**KIRKLEES METROPOLITAN COUNCIL
INVESTMENT & REGENERATION SERVICE**

DELEGATED DECISION TO DETERMINE PLANNING APPLICATIONS

Reference No:	2023/62/93705/W
Site Address:	6, Share Hill Road, Wellhouse, Huddersfield, HD7 4JQ
Description:	Erection of front dormer extension and loft conversion
Recommending Officer:	Tom Hunt

DECISION – REFUSED

Proposed cross section (1:100)

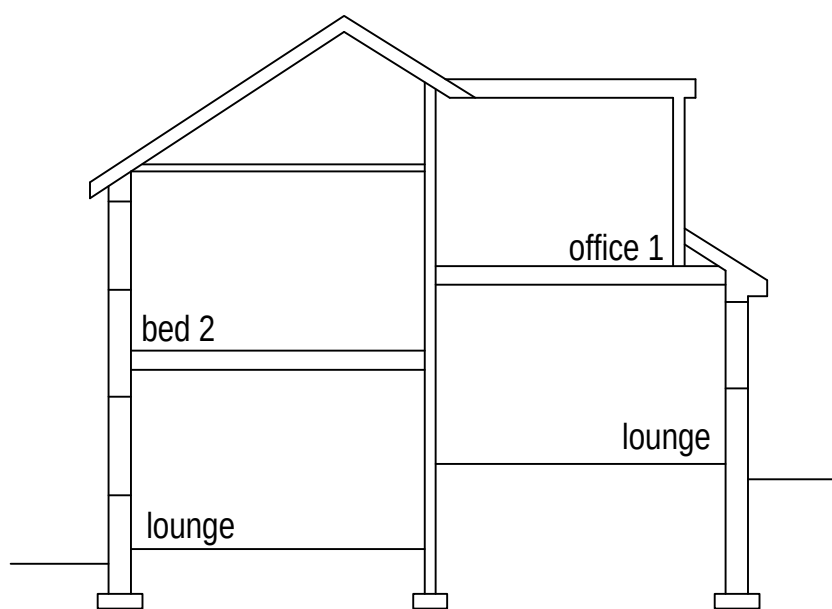
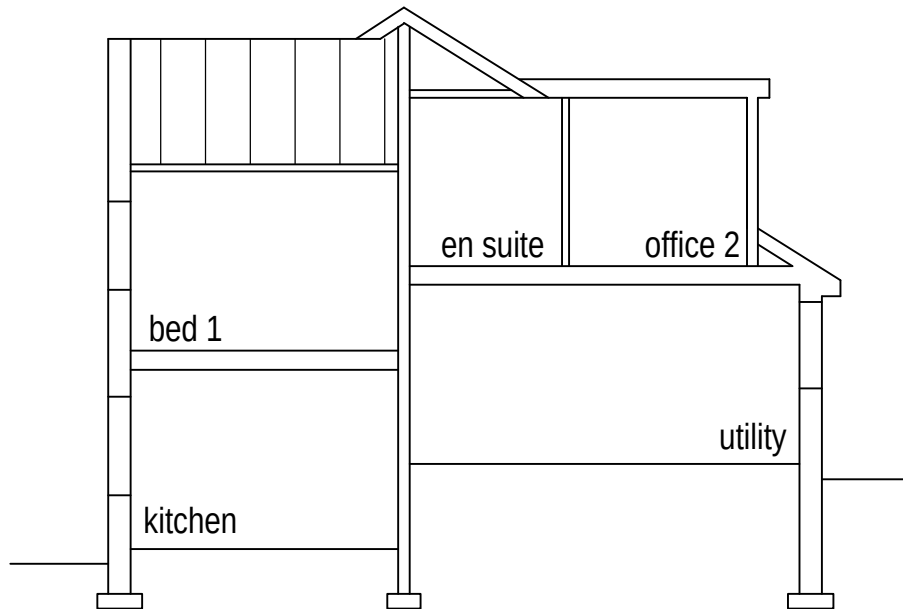
It would project 4m from the roof plane, be 11m width and have an overall height of 2.5m to have a 44m³ increase in volume.

Proposed front/west facing elevation (1:100)

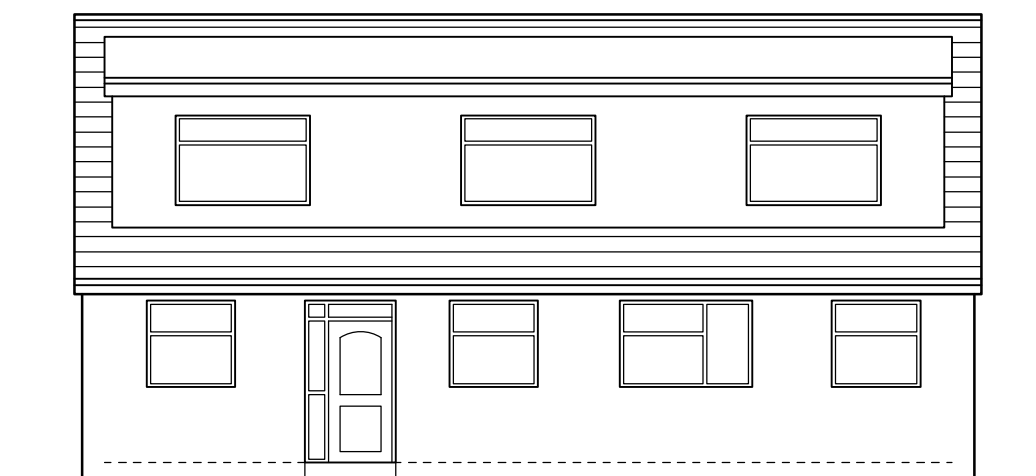
The proposal would not be to the rear, not be considered a small dormer being set almost the full width of the host and would not appear in keeping with the local character of the streetscene. While front roof interruptions have consisted of front gable extensions (no. 8), there are no front dormers to aid in the scheme to appear visually integrated within the streetscene.

The proposed materials of grey grp cladding with roof membrane would introduce low quality materials and an incongruous 'shed' dormer design to the host and would fail to respect or enhance the setting of the Listed Building or the Conservation Area.

As such, the proposal would appear as a dominant and uncharacteristic addition to the host and would introduce greater demand for parking to the front of the host with associated vehicular clutter in the street scene, harming the character and setting of the adjacent Listed Building and Wellhouse Conservation Area, and failing to comply with SPD guidance on dormers and Key Design Principles 1 and 2 of the SPD.
